To: Eoin Hickey
Cc: Ben Lusher
Subject: RE: SSD 15_7317 - Public response to Development

June 21 : 11.00am

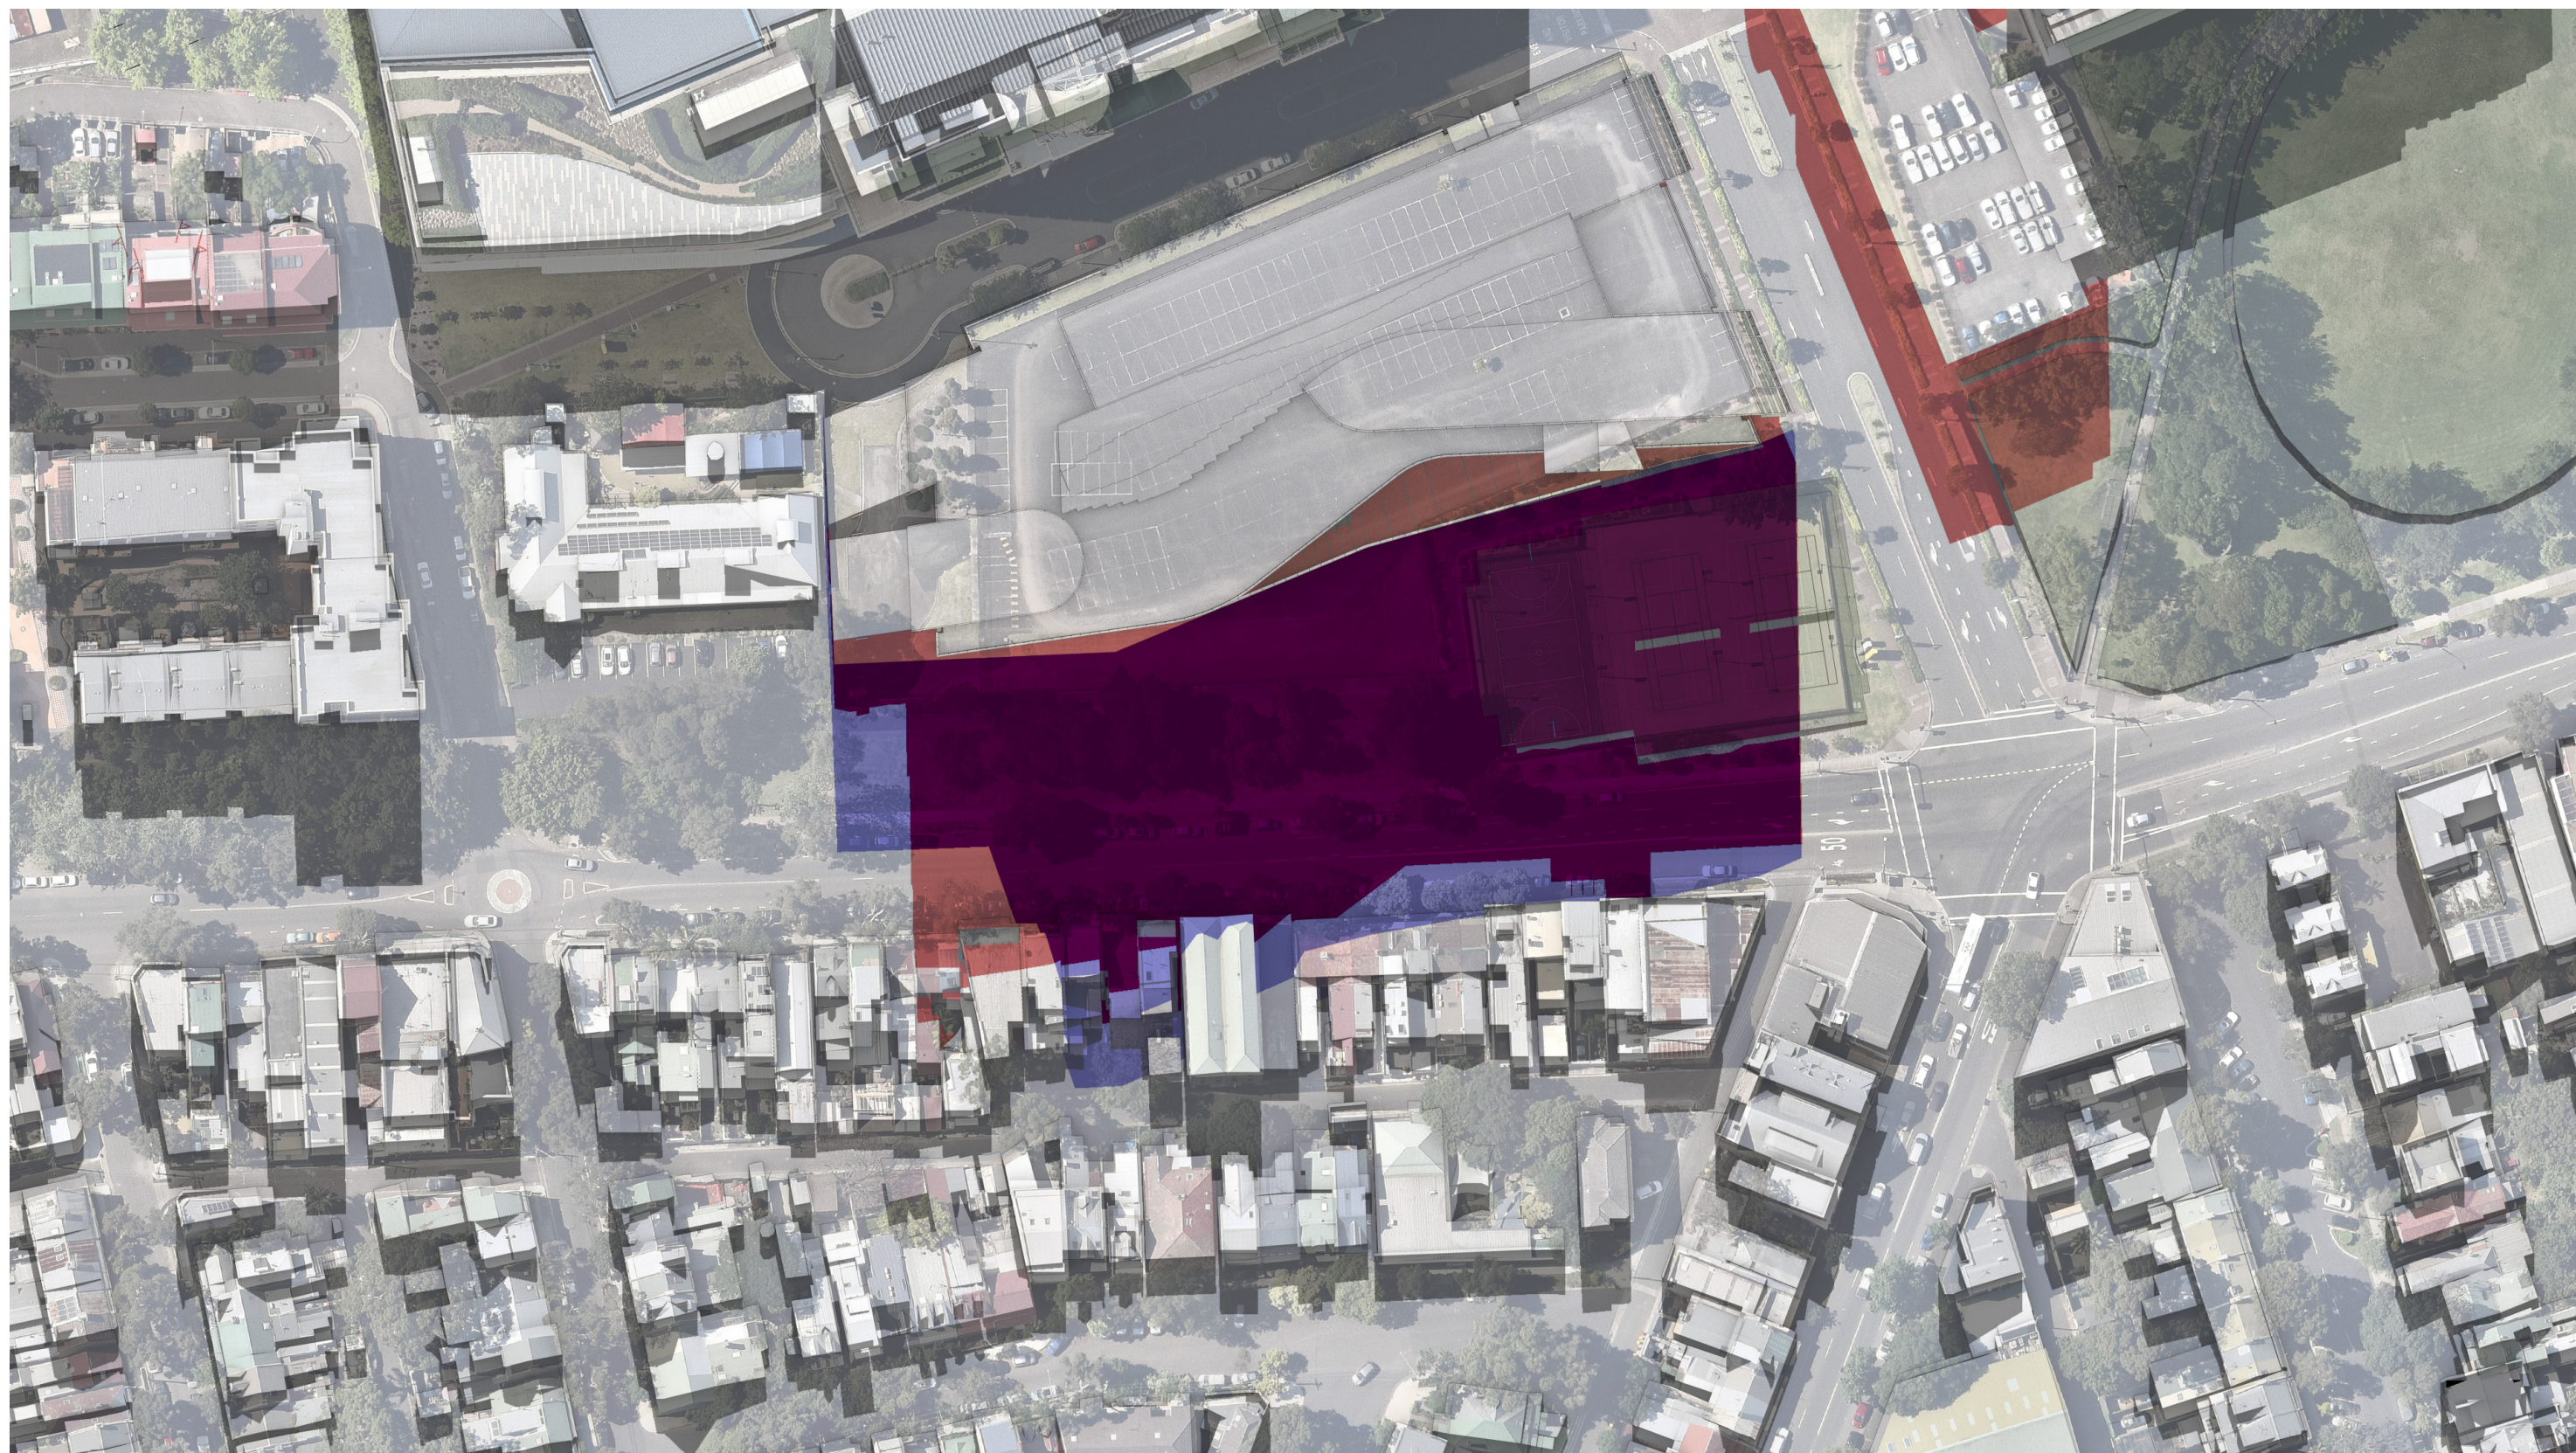
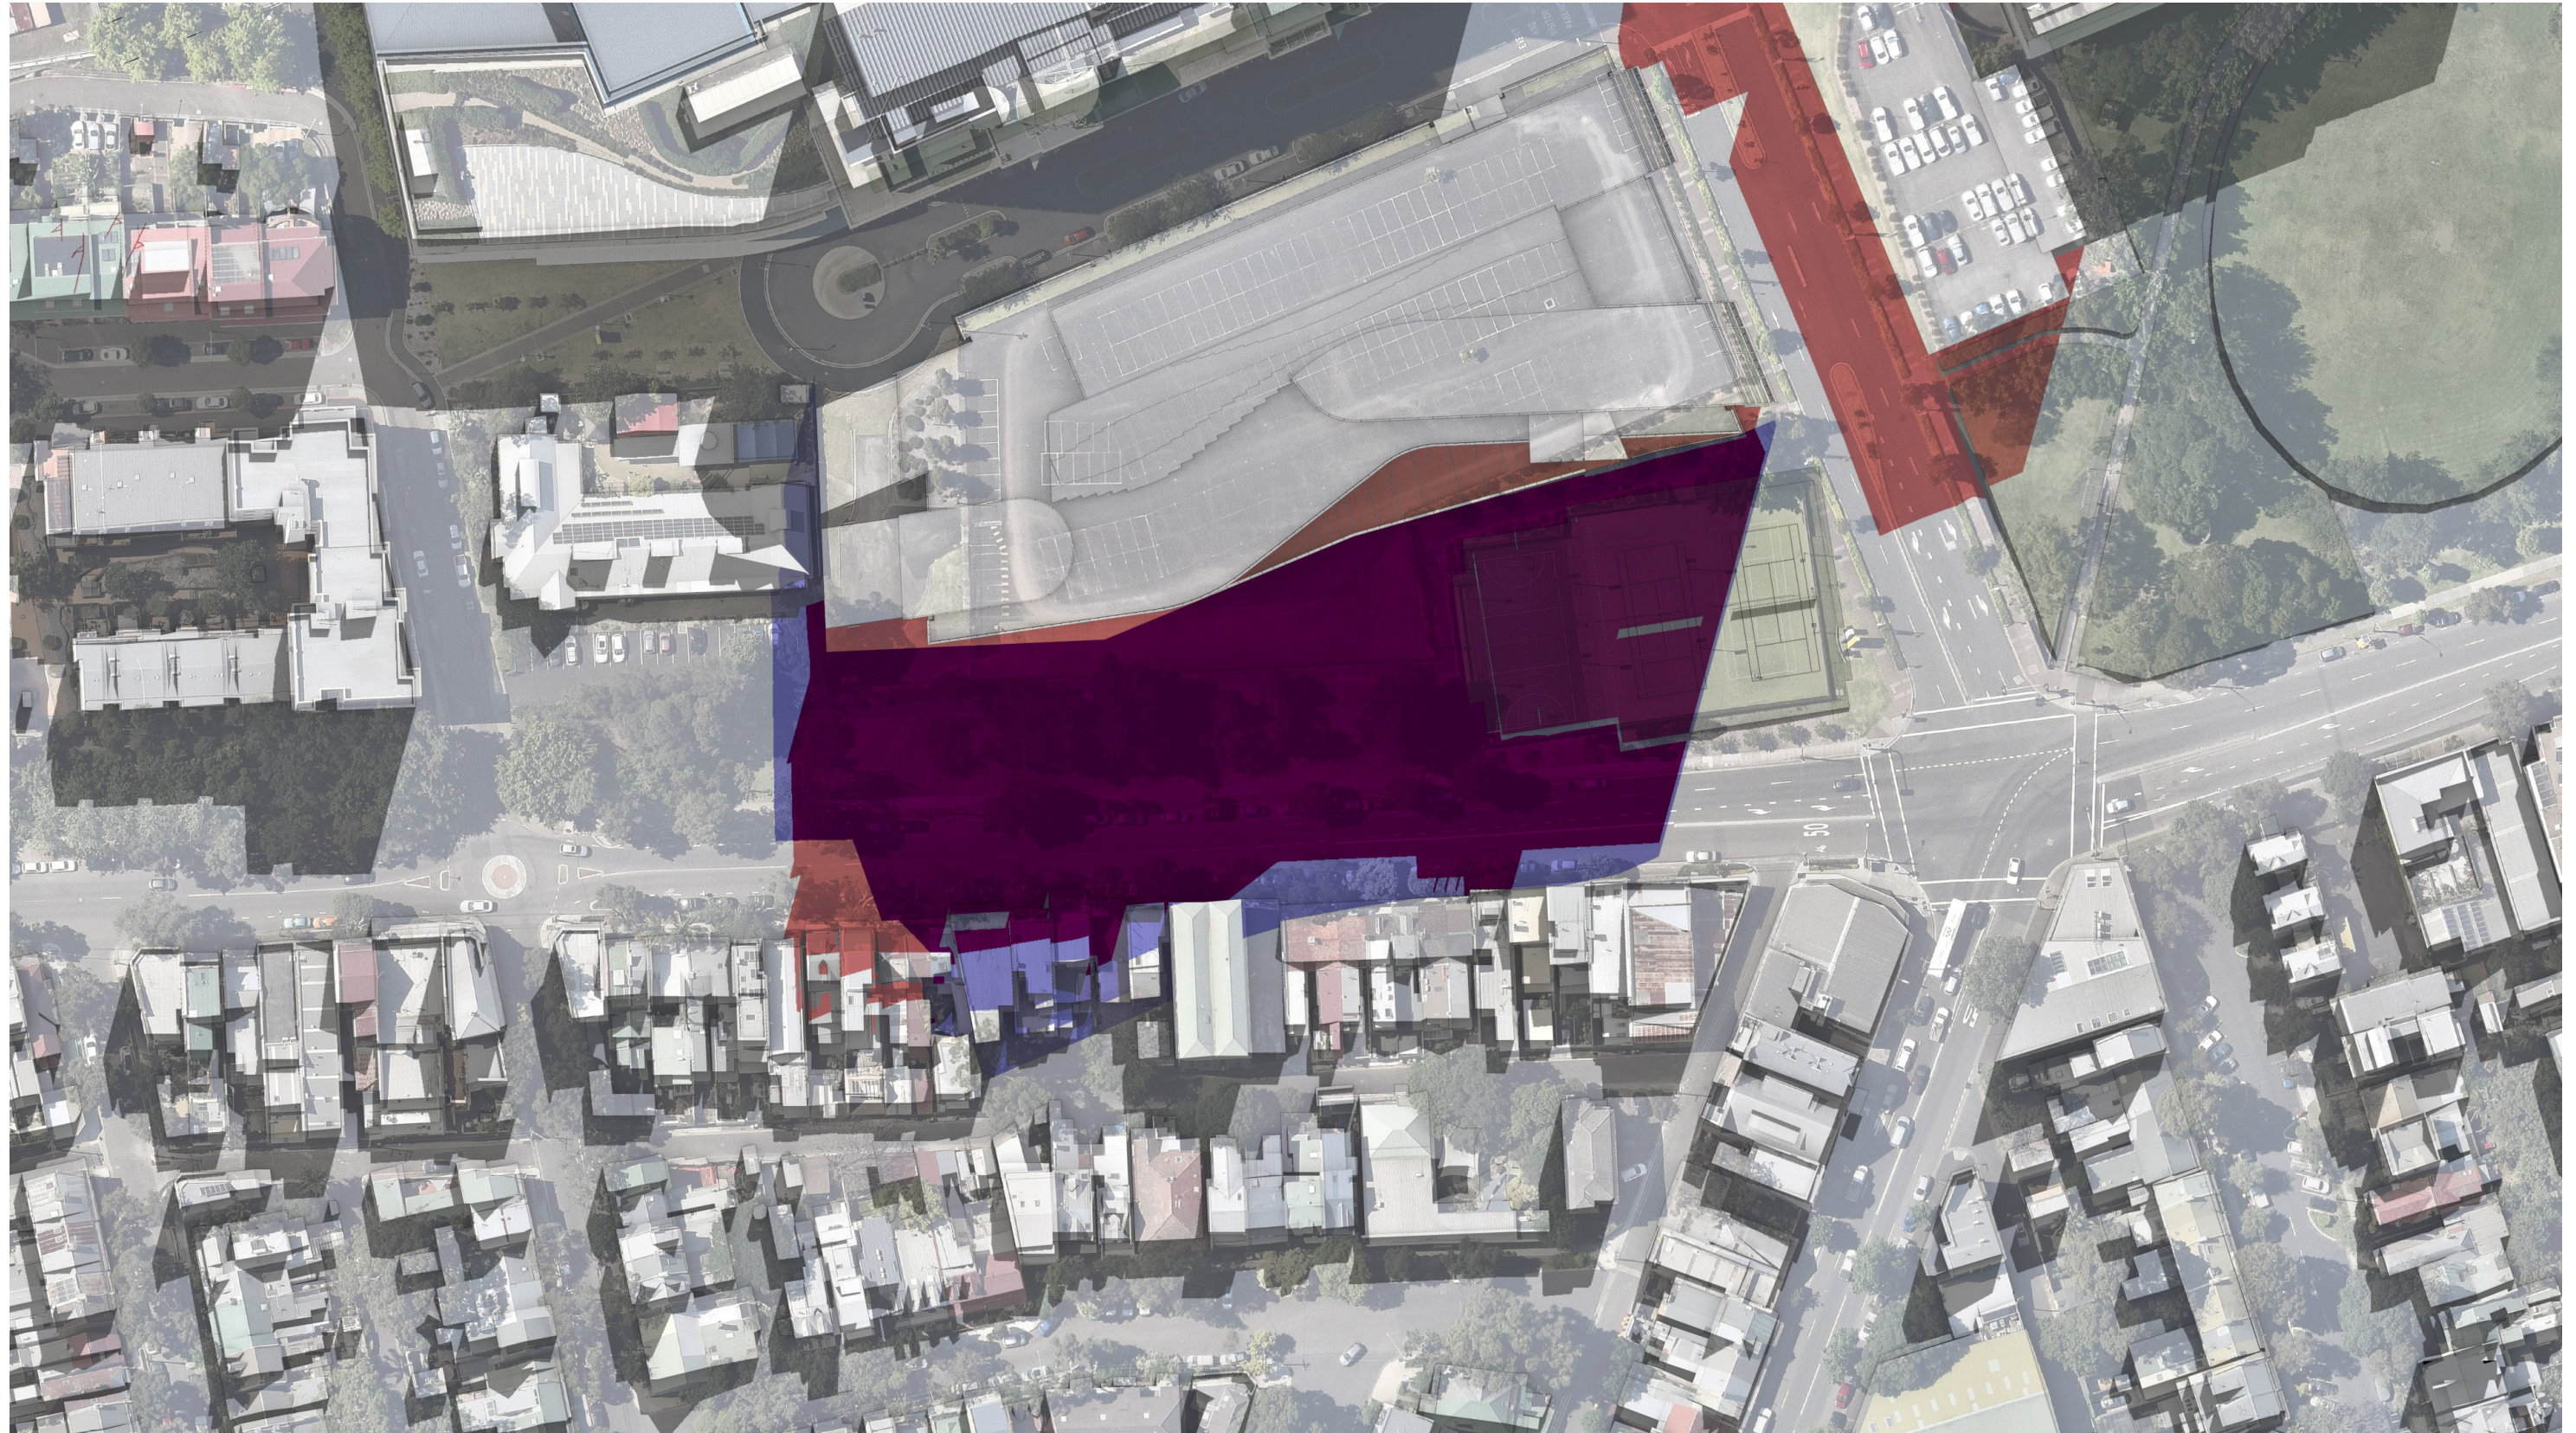
Finally, outdoor play areas of child care centers are designed so as not to be overlooked by adjoining properties. A 50 plus metre building towering over the child care outdoor play area was not responded to appropriately despite the risk to the children and carers safety and privacy both during and after construction while highlighting that the existing Channel 7 building is already impacting the local surrounds is not a valid argument for allowing the development to go ahead at the proposed height.
